APPLICATION FOR A NON MATERIAL AMENDMENT UNDER SECTION 96A OF THE TOWN AND COUNTRY PLANNING ACT (1990) ACT TO REF. 75111/APP/2022/1007 IN CONNECTION TO CONDITIONS 2 AND 10 WITH REGARDS TO:

- **ENERGY CENTRE 2**
- **ENERGY CENTRE 3**
- **CANAL ACCESS RAMP**

LAND AT BULLS BRIDGE INDUSTRIAL ESTATE, NORTH HYDE GARDENS, HAYES, UB3 4QQ

EC2 Floor Plans & Top View

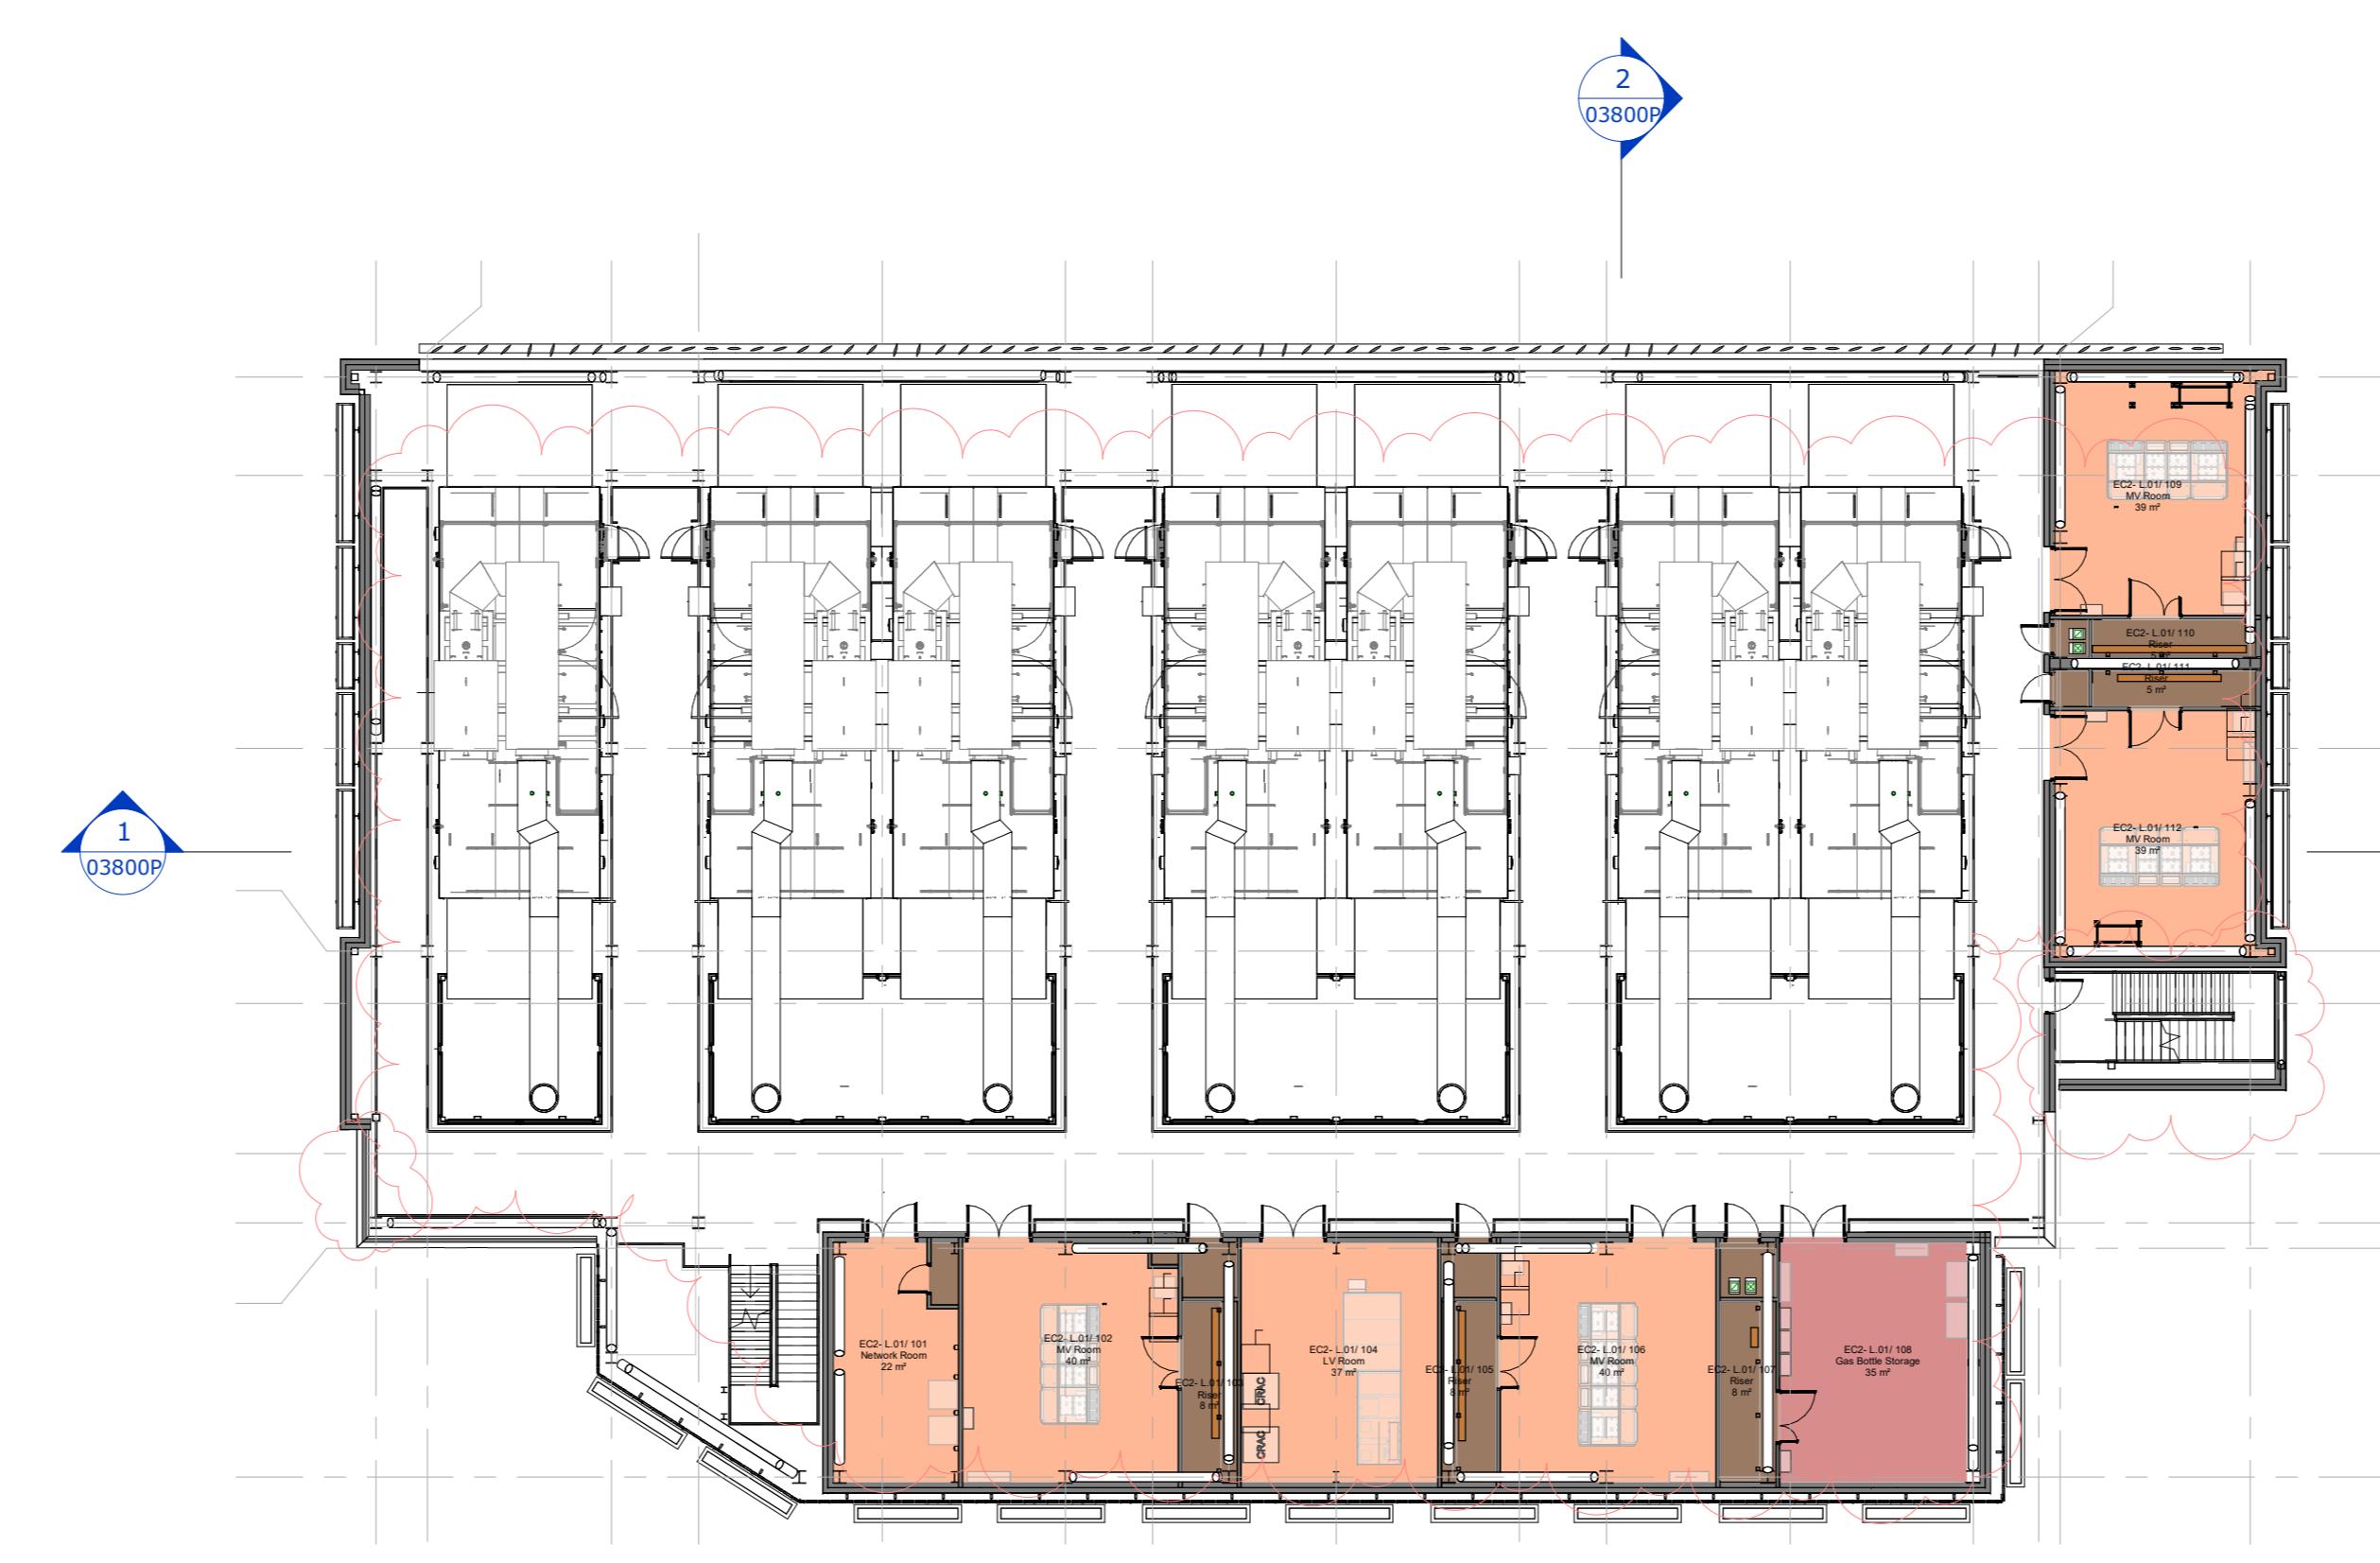
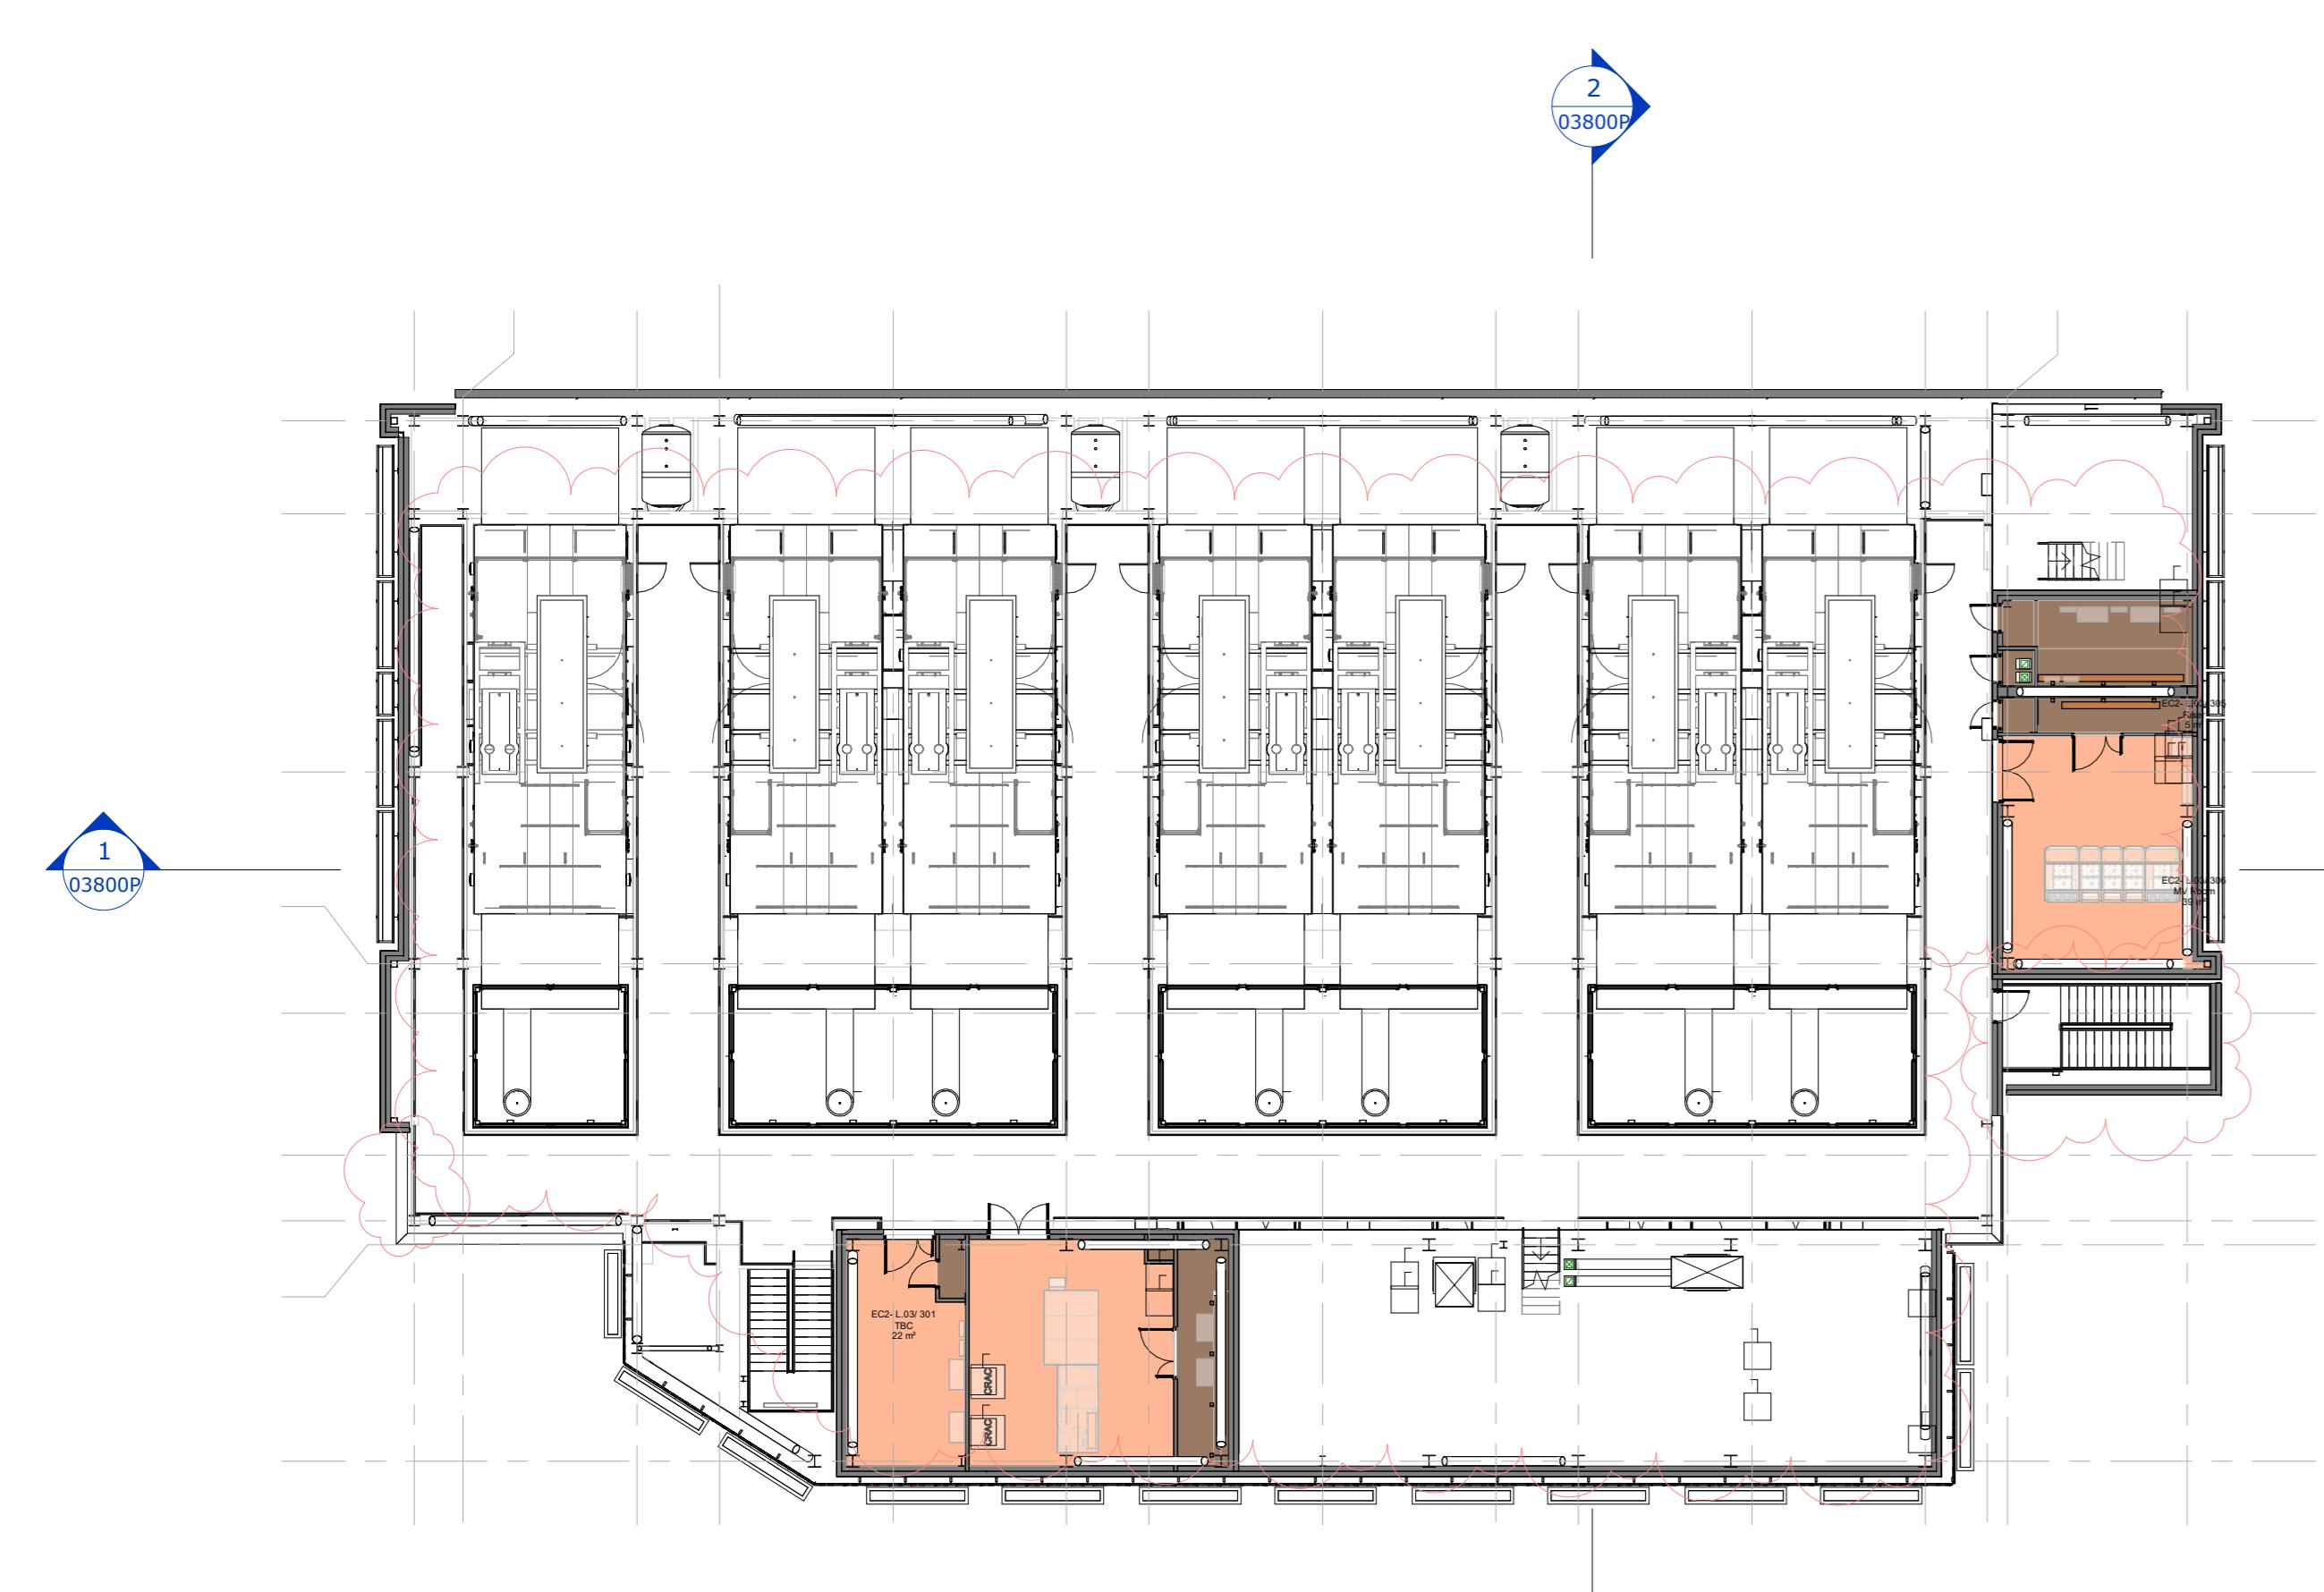
- Installation of an additional staircase at the southeastern corner of the building. This will be clad in the same materials as the wider building;
- Modest refinement of the footprint of Energy Centre 2 along its western and southern boundary. As shown on the plans submitted, these changes are modest in the extreme and could reasonably be considered to be de minimis;

- To facilitate plant replacement, there is a requirement for the replacement of the brickwork along the northern elevation of Energy Centre 2 with louvres and the replacement of landscaping with planters to facilitate access;

- Reconfiguration of the green wall arrangement along the building's southern and western elevations. Importantly, the quantum of green walling (and the urban greening factor that is achieved) remains unchanged; and

- Reconfiguration of the building's internal arrangement which will mean that the heat rejection stacks will no longer be visible.
